## Appeal Decision

**Appeal Ref: APP/R5510/D/25/3365012**

**25 The Chase, Eastcote HA5 1SJ**

- The appeal is made under section 78 of the Town and Country Planning Act 1990 (as amended) against a refusal to grant planning permission.
- The appeal is made by Mr Bhuva against the decision of the Council of the London Borough of Hillingdon.
- The application ref. is 18233/APP/2024/3358.
- The development proposed is a new detached garage.

PROPOSED DETACHED GARAGE 25 The Chase, Pinner HA5 1SJ			
PROPOSED PLAN & ELEVATIONS & SECTION			
Scale:	1:100 @ A3	DEC 2024	Dwg. 24_038_P1

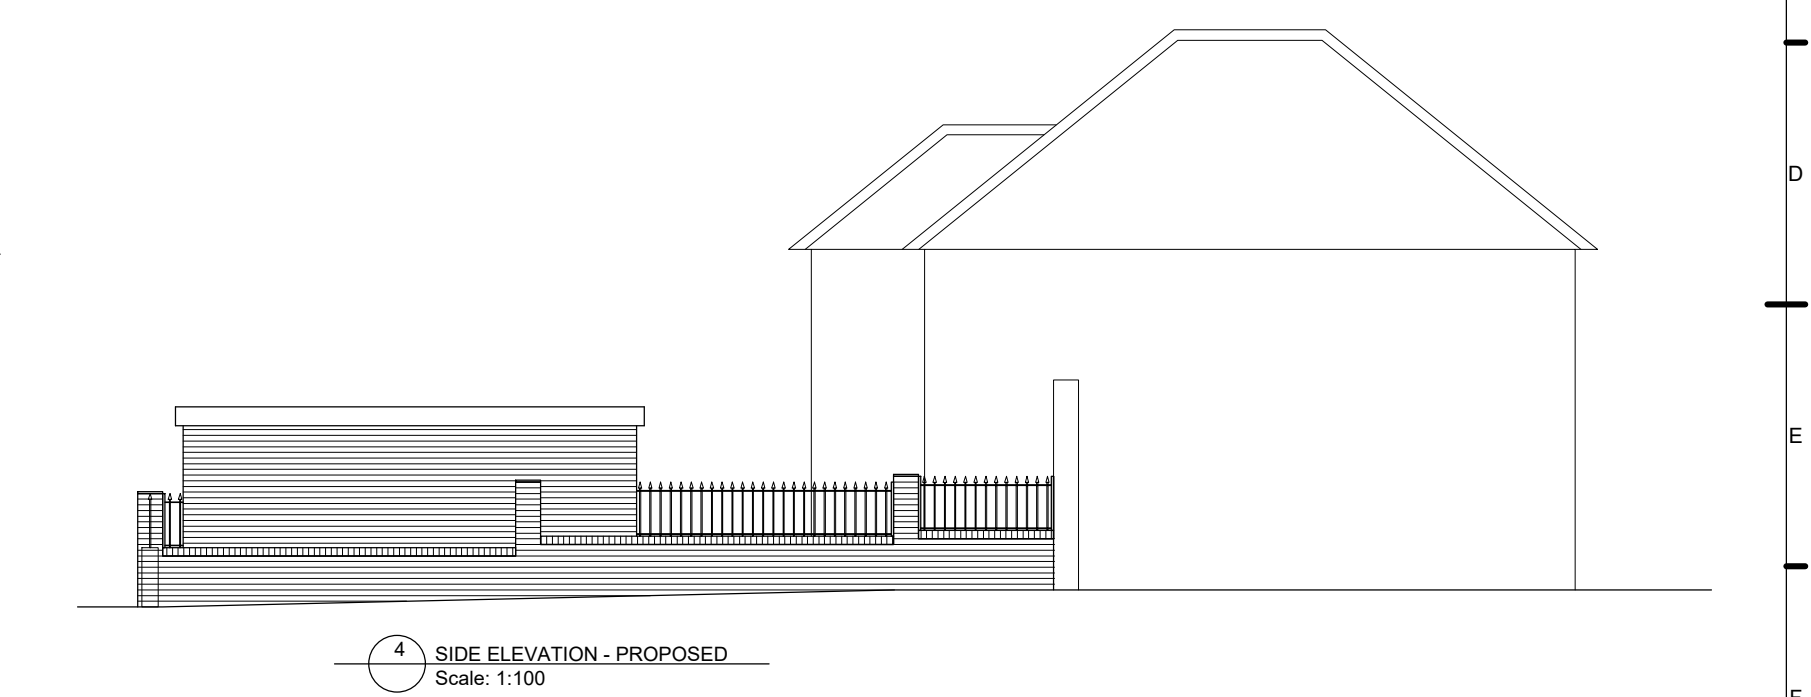
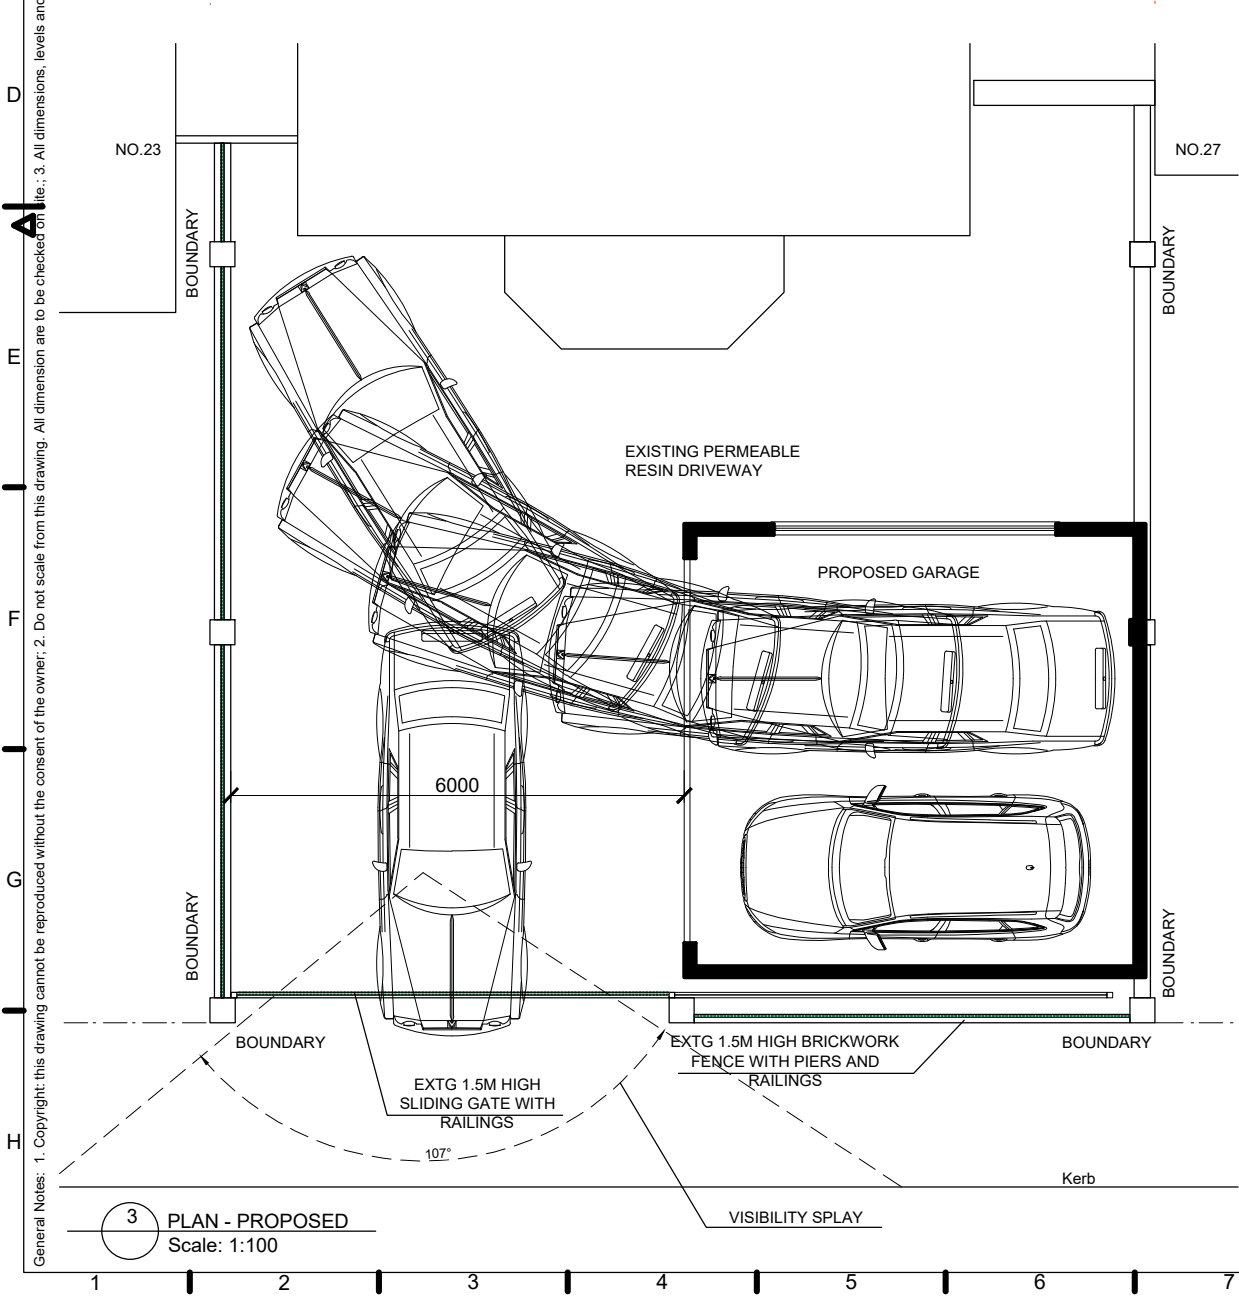
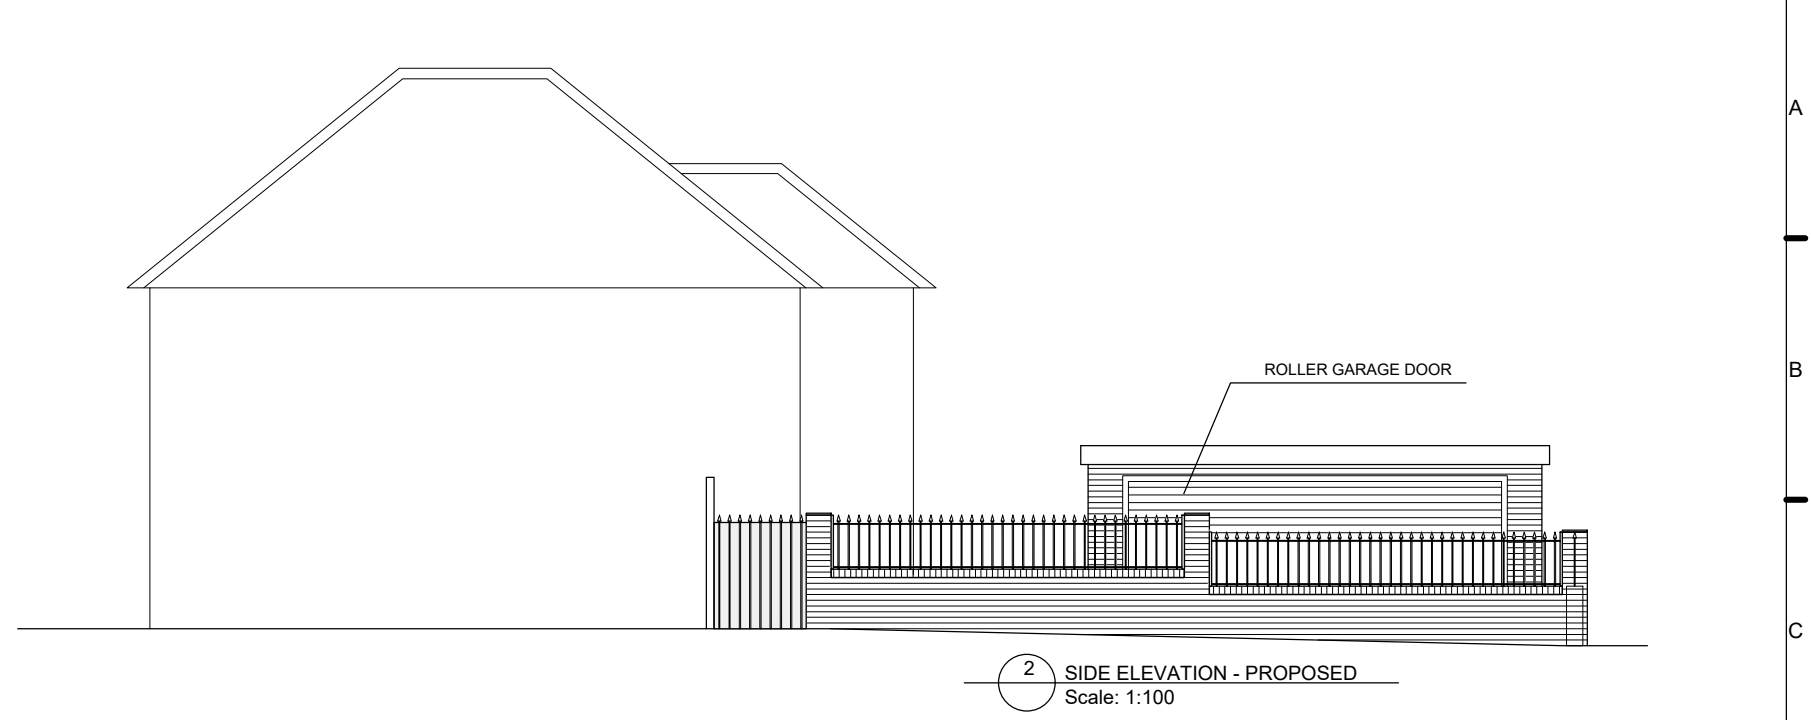
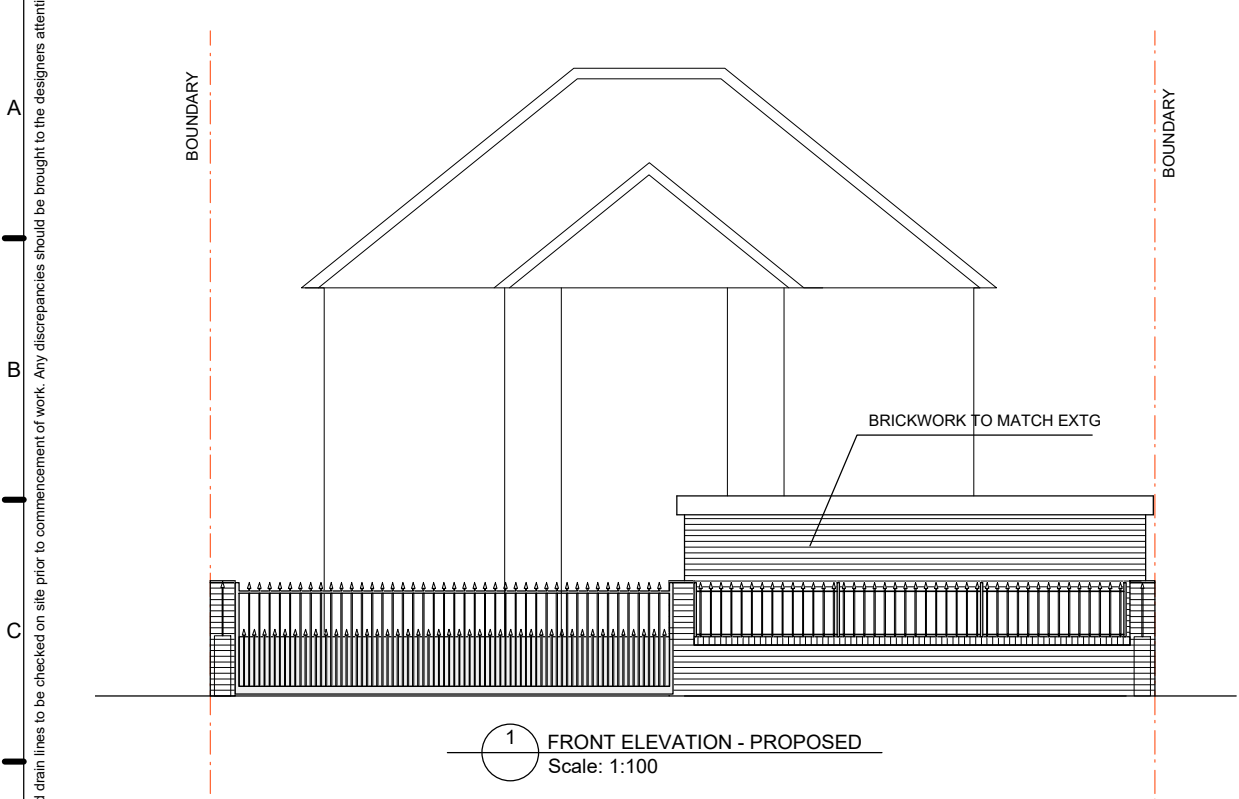
7. The proposed development is to erect a detached garage in the corner of the front garden, about a metre in from and aligned with the street. It would be in brickwork to match the existing wall, have a flat roof, roller door for vehicular access and glazed sliding doors on the side facing the house.

9. Several of the examples are some way distant from the appeal site and in different character contexts. As there are no similar such buildings in front gardens within the nearby vicinity, the proposal would appear out of place, and reduce both the intervisibility of the house with the street and the sense of spaciousness.

10. This proposal would therefore harm the character and appearance of the area, contrary to Policy BE1 of the Hillingdon Local Plan: Part One - Strategic Policies (November 2012) and Policies DMHB 11, DMHB 12 and DMHD 1 of the Hillingdon Local Plan: Part Two - Development Management Policies (January 2020).
